Address RYEFIELD RESIDENTIAL CARE HOME RYEFIELD AVENUE HILLINGDON

Development: Details pursuant to conditions 20 (Air extraction system) and 22 (Scheme for the control of noise from plant and/or machinery) of planning permission dated 1/12/14, 11838/APP/2014/2350: Amendment to condition 3 of planning permission 11838/APP/2013/2650 dated 31/12/2013 to amend the approved plans to adjust external openings, reconfigure the internal layout and alter the location, design and size of the basement (S73 application).

LBH Ref Nos: **11838/APP/2015/3917**

Scale 1:100(A4) 1:200(A3)	Date -	Drawn by -	Checked -
Drawn Date North Elevation Plan			
PRELIMINARY

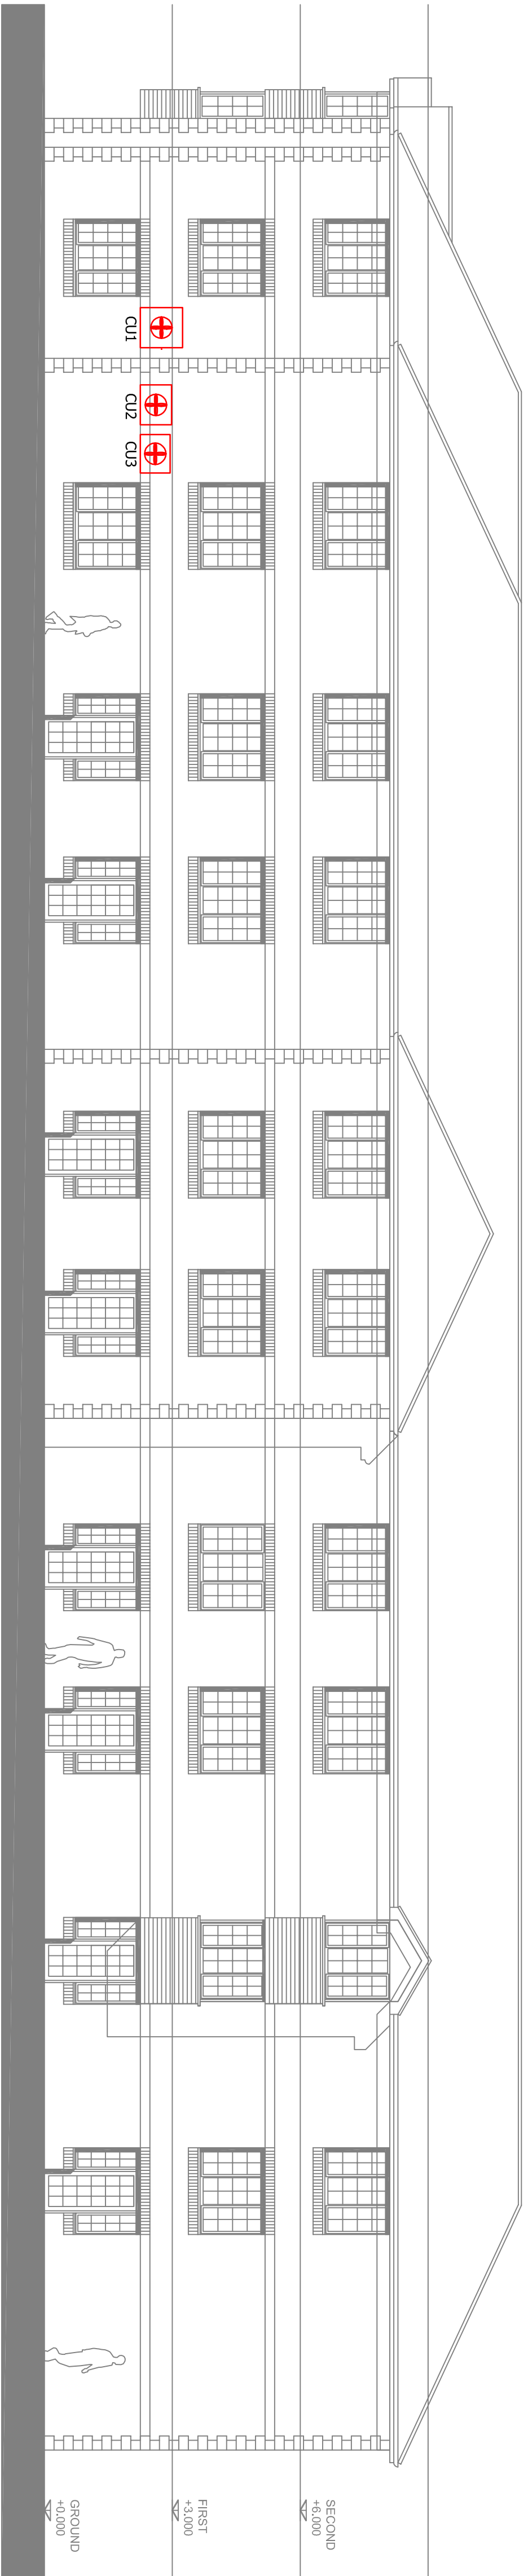
A previous noise assessment had been carried out on this site, and that gave a background level of 40dB (nighttime). The driers proposed are to have a running level of approximately 68dB at 1m distance. There has been no information received regarding mitigation of the driers, nor the plant noise. In the absence of this information, the condition cannot be discharged.

The submission, in the absence of detailed plans showing the precise route of the ducting to serve the flues and extracts and appropriate mitigation for the plants and driers, would fail to safeguard the amenities of the adjoining occupiers and not comply with Policy OE1 of the Hillingdon Local Plan (November 2012) and London Plan (March 2015) Policies 7.1 and 7.14.
